STATE OF WASHINGTON
DEPARTMENT OF ECOLOGY

Re: SEPA Register 202101748, LP-21-00001

Thank you for the opportunity to comment during the Optional Determination of Non Significance process for the Bull Ranch subdivision of 45.02 acres into 138 lots, proposed by Lathrop Development Company. We have reviewed the documents and have the following comments.

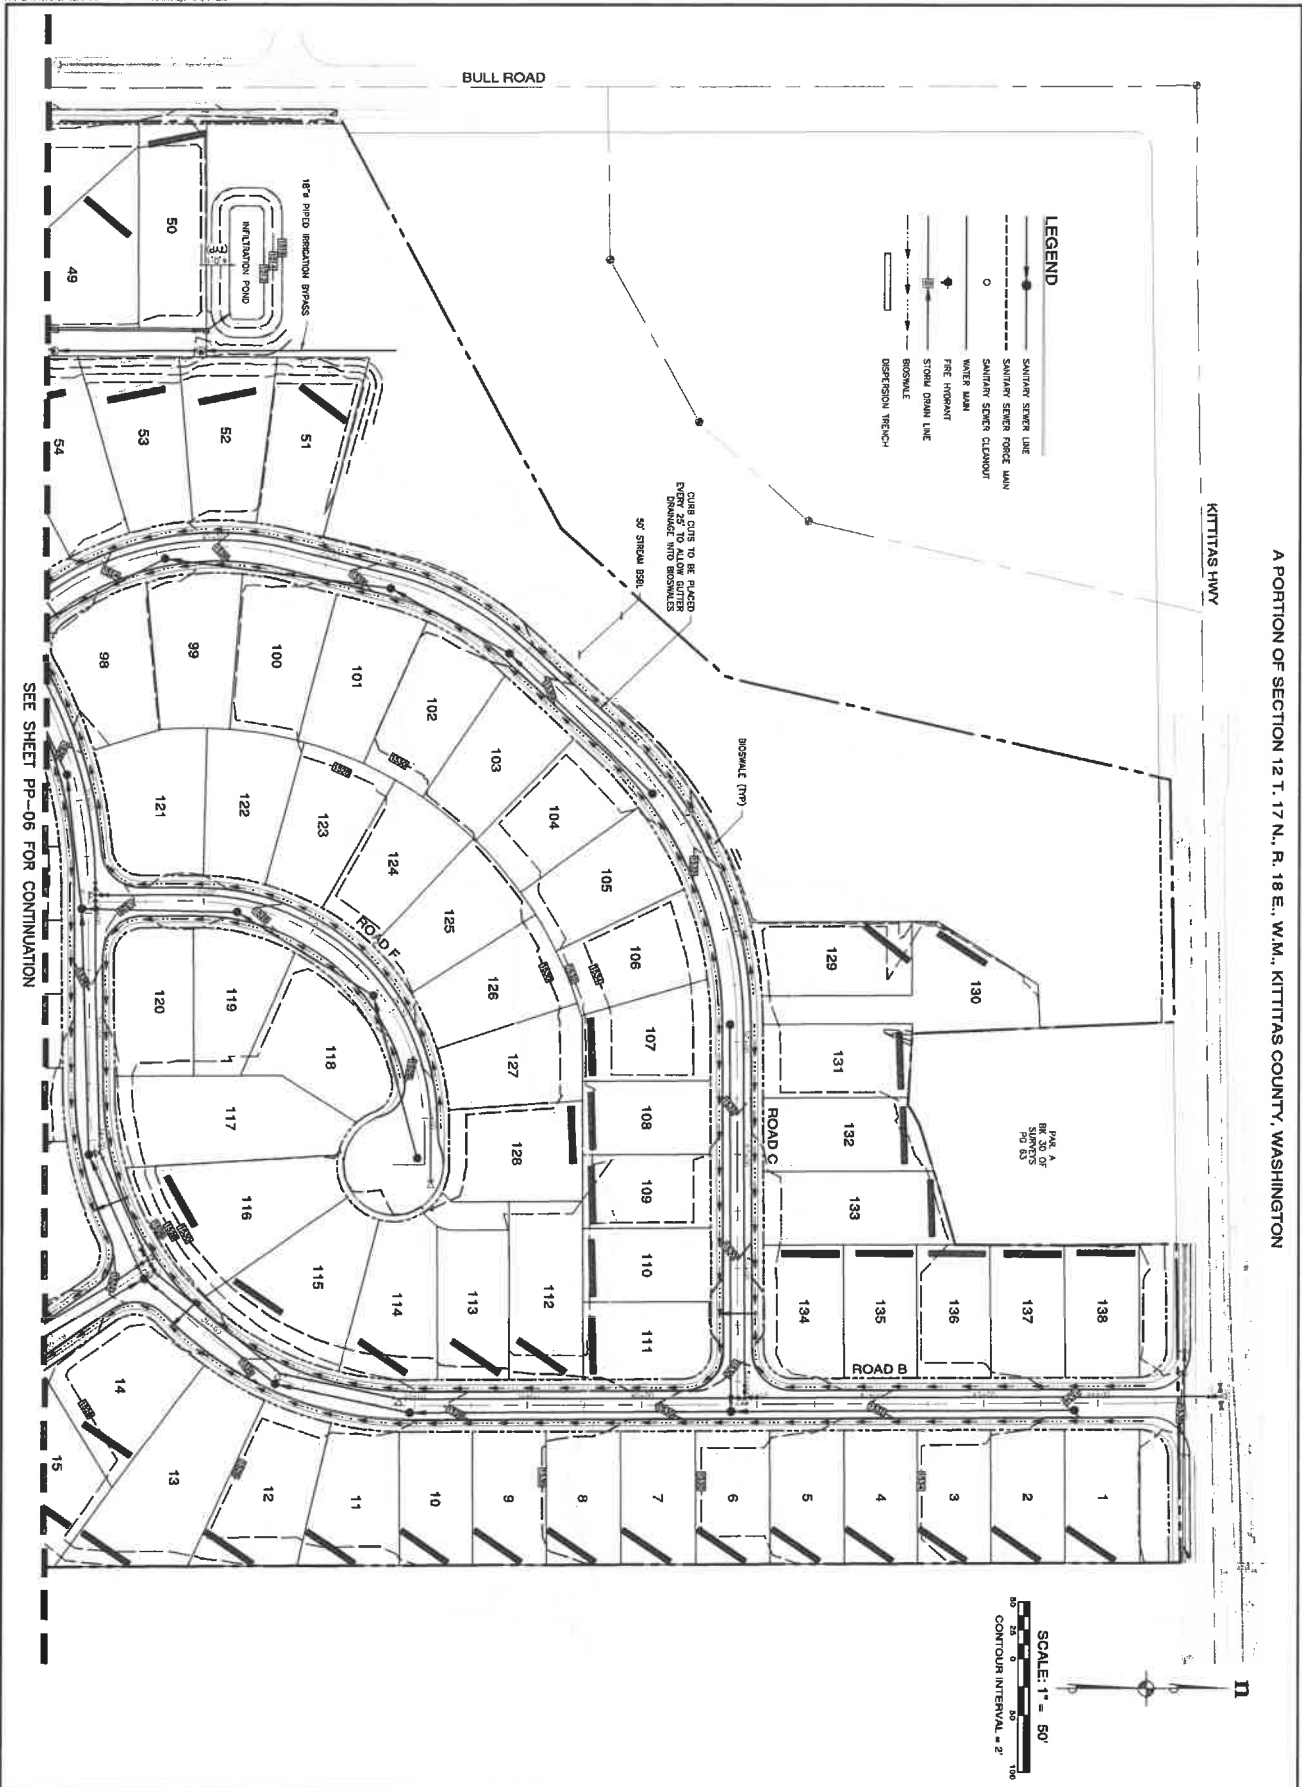
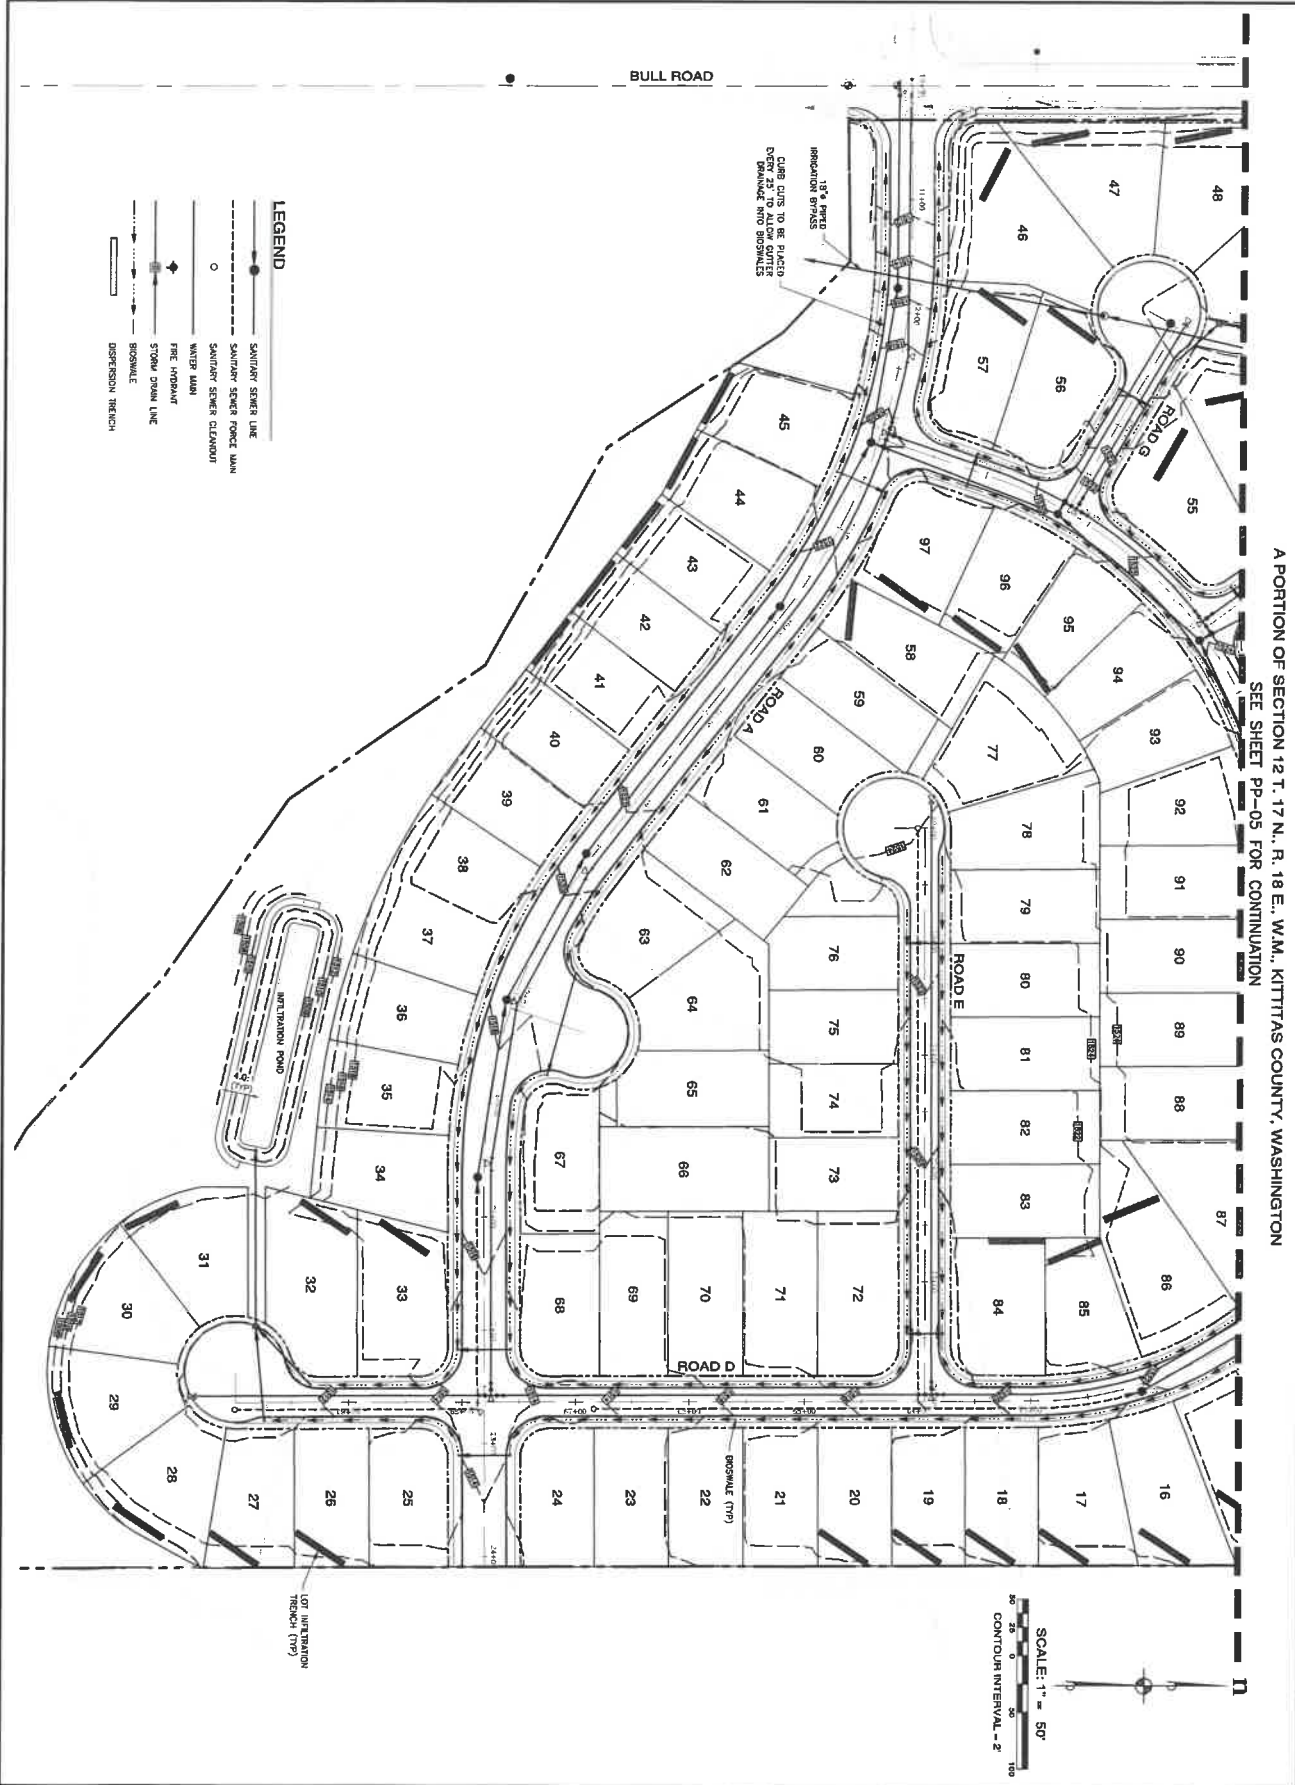
Under RCW 90.03.350, a Dam Safety construction permit is required for those dams or ponds which can impound a volume of 10 acre-feet or more of water or other liquids, above ground level. The Bull Ranch development project references stormwater facilities including an impoundment as part of this development. To determine if a Dam Safety construction permit is required for your project, the applicant must submit a set of construction plans to:
